Rezoning Transportation Analysis

Petition Number: 2021-082

General Location Identifier: 15720715

The site is located adjacent to Craig Avenue, a City-maintained major collector near the intersection of Craig Avenue and Falcon Street, an unopened public right-of-way. A Traffic Impact Study (TIS) is not needed for this site. The site plan commits to constructing Falcon Street and providing an 8-foot planting strip and 6-foot sidewalk on Craig Avenue and Falcon Street in accordance with the Charlotte Walks and Chapter 19 of the City's Ordinances. All outstanding CDOT comments have been addressed.

RZ-1.0

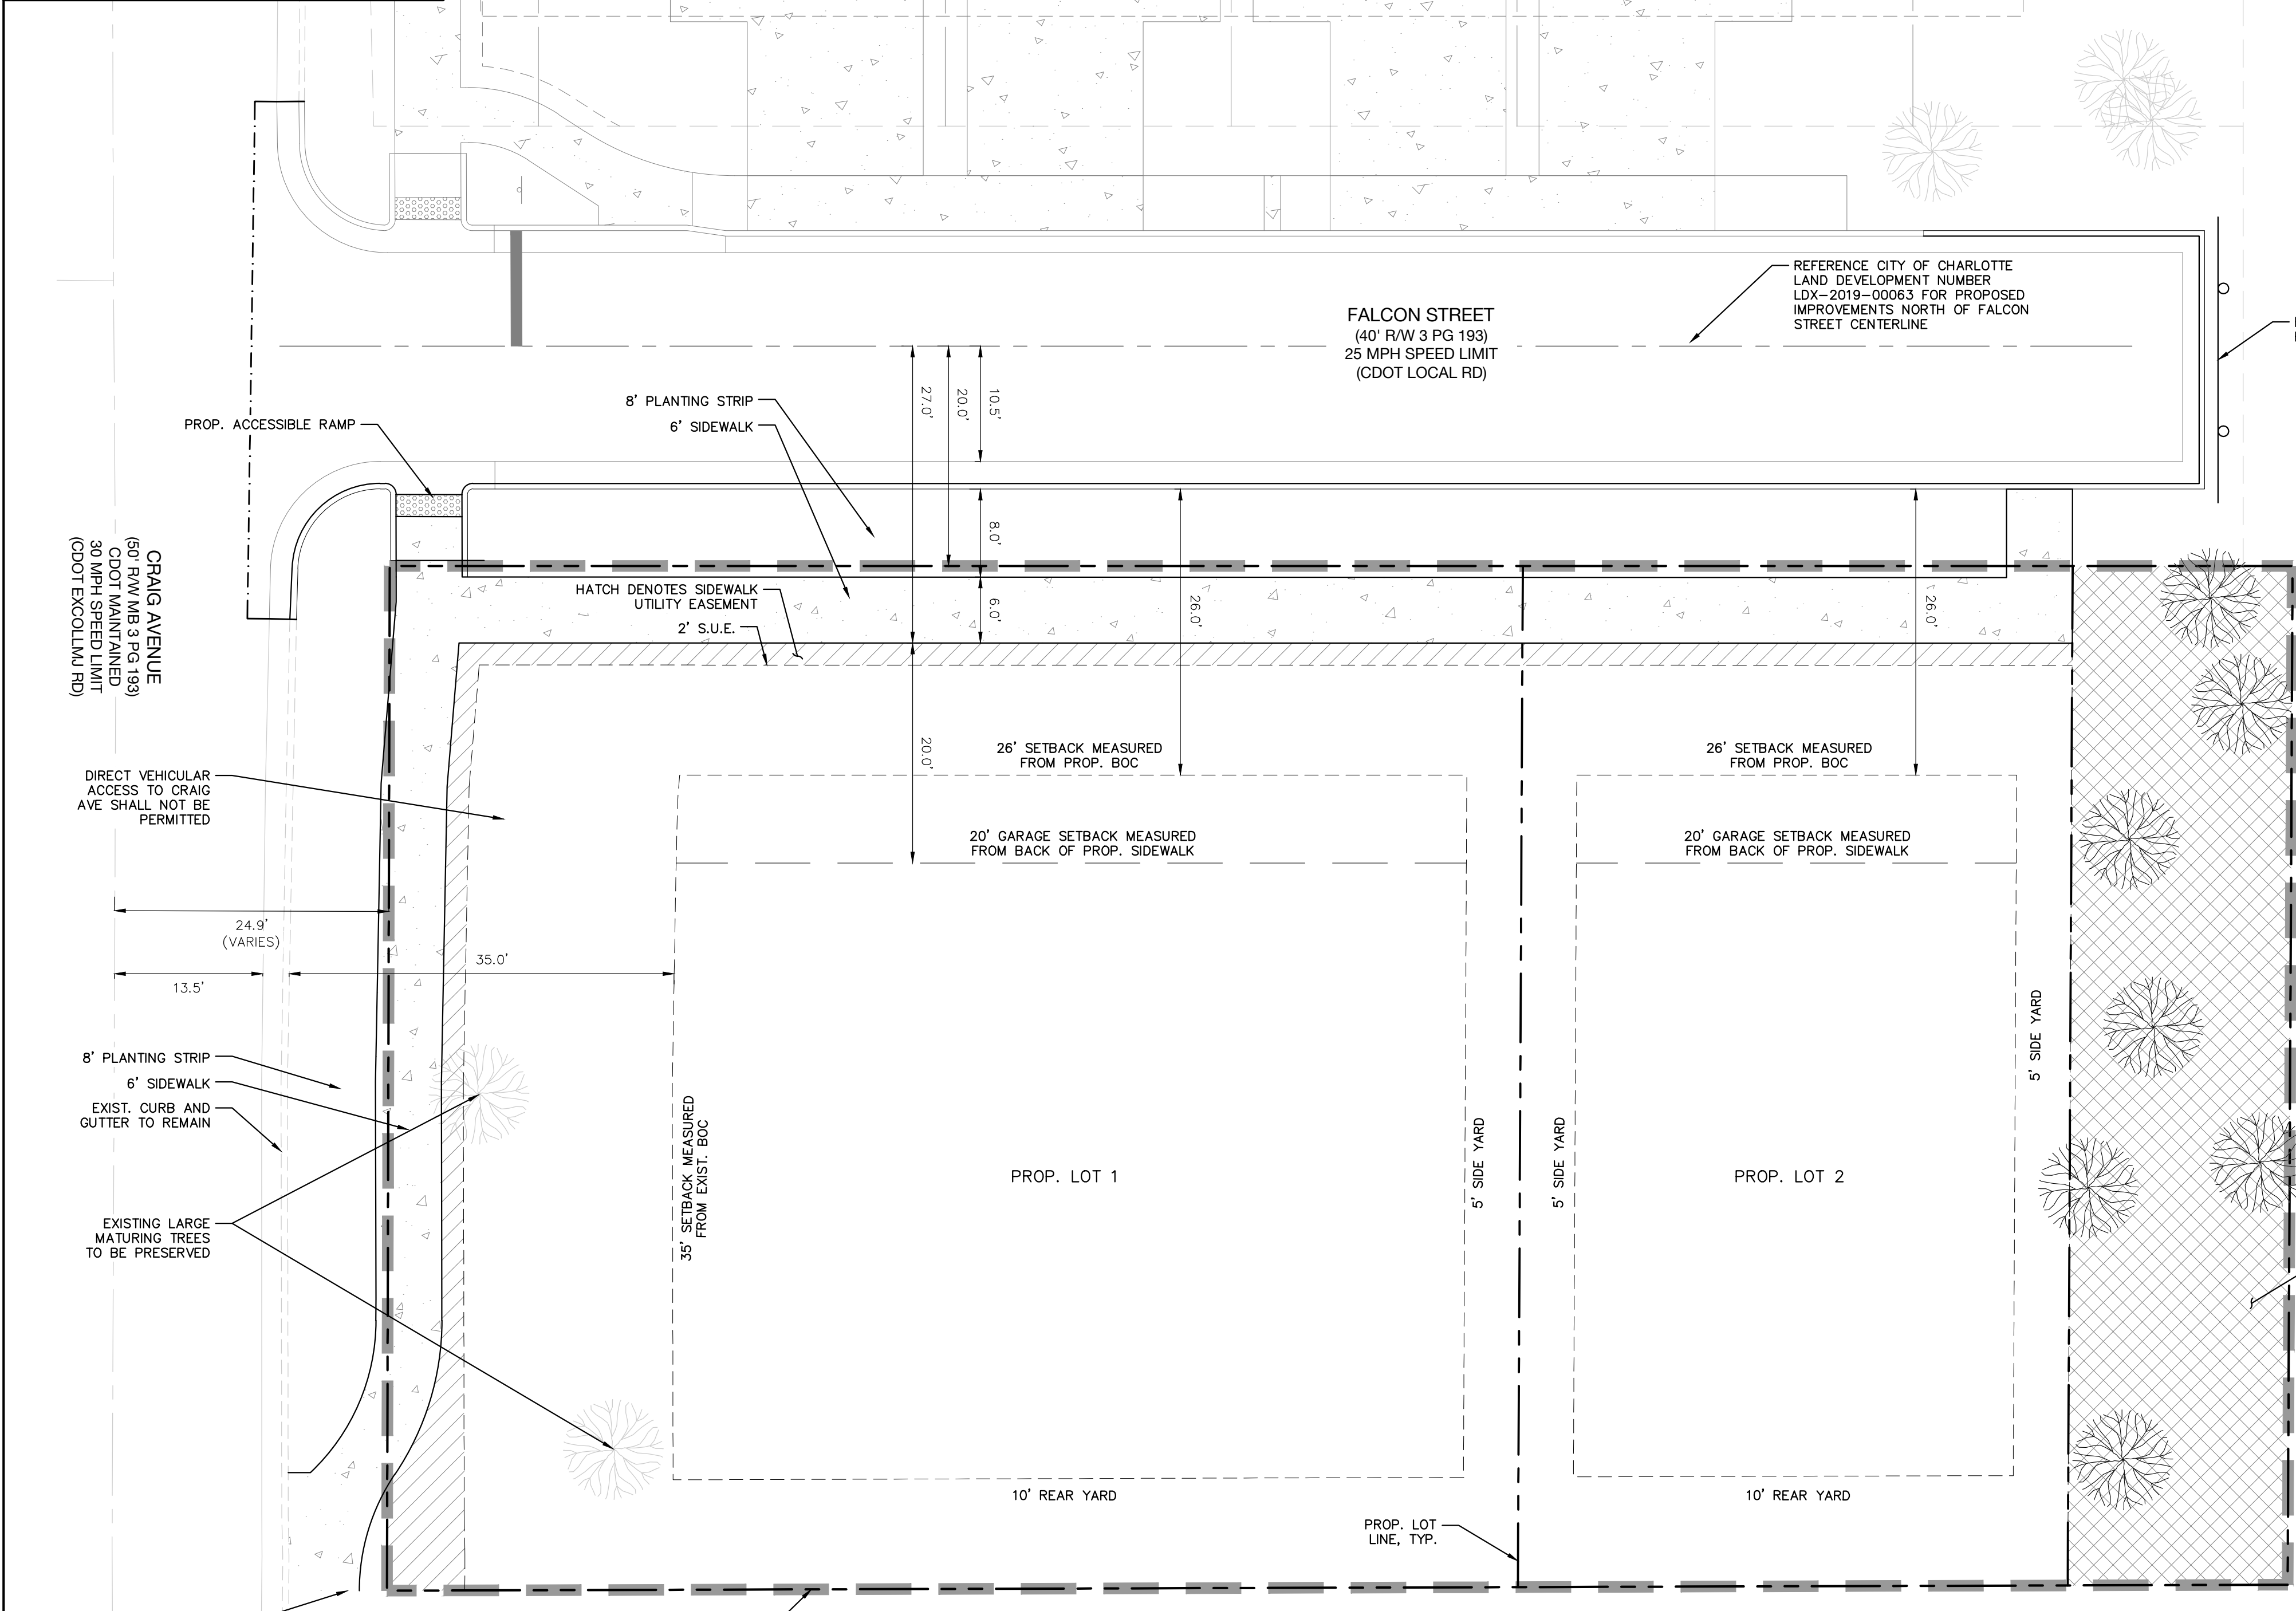
- ~~1. A Traffic Impact Study (TIS) is not necessary for the complete review of this petition due to the site generating less than 2,500 daily trips. If during the permitting process the site generates more than 2,500 daily trips, then a traffic study will be required.~~
- ~~2. Revise site plan note that Falcon Street is City-maintained. Although it appears to be public right-of-way, it is not currently City-maintained.~~
- ~~3. The residential narrow street type is not valid for this density. Revise site plan accordingly.~~
- ~~4. Revise site plan to reflect the Falcon Street stub extending all the way to the eastern property line.~~
